Mark Youngman
Development Management Group Manager
Hertfordshire County Council
Postal Point CH0242
County Hall
Pegs Lane
Hertford
SG13 8DE

District ref: 6/2023/2136/COND
HCC ref: WH/18732/2023
HCC received: 25 January 2024
Area manager: Manjinder Sehmi
Case officer: Chris Carr

Car Park Salisbury Square Hatfield AL9 5AD

Submission of details pursuant to condition 2 (construction management plan), 3 (archeological written scheme of investigation), 4 (Arboricultural method statement), 7 (petrol interceptors and treatment devices) and 9 (surface water drainage) on planning permission 6/2021/3422/MAJ

Routing plan

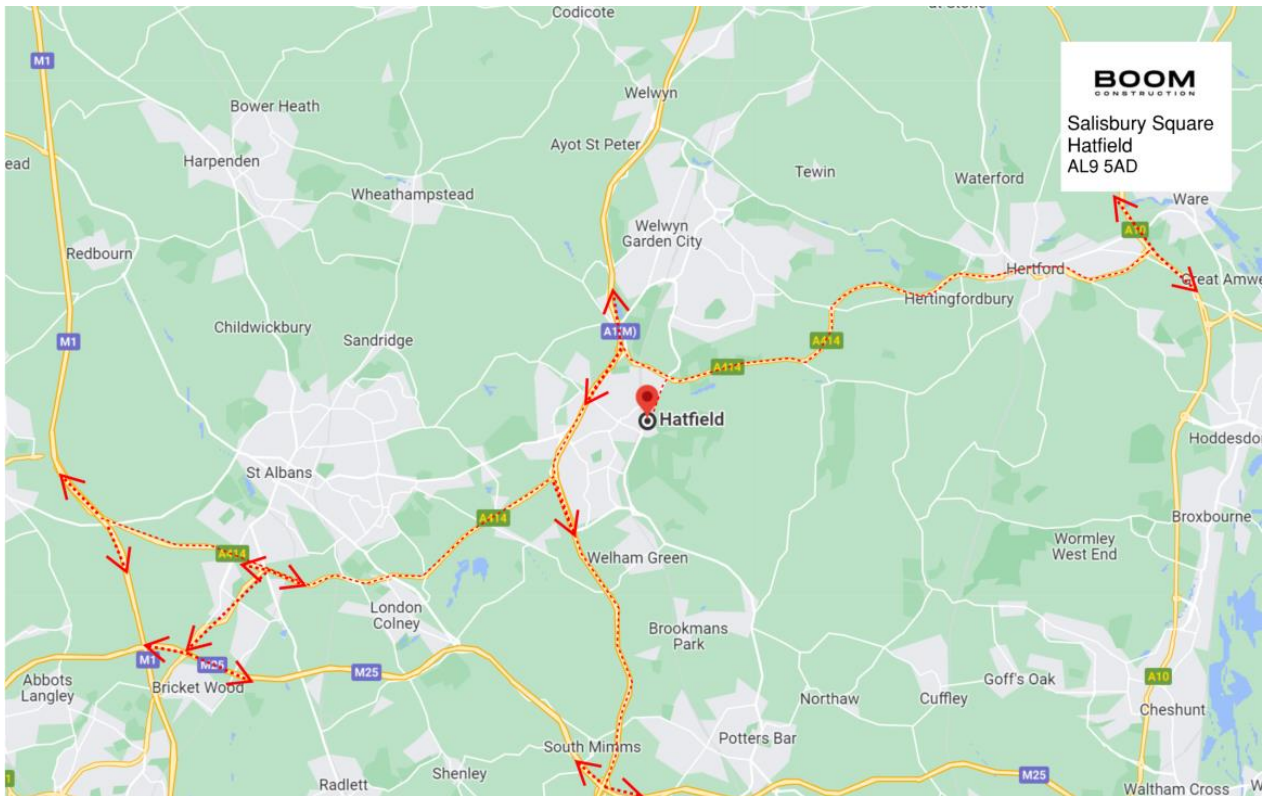
The updated CMP includes a routing plan. Earlier, the CMP stated that no deviations or special controls are in place on any of the local roads. It is expected that deliveries would be from the site via the A1000 Great North Road and the A414, A1 & M1/M25. This is considered acceptable.
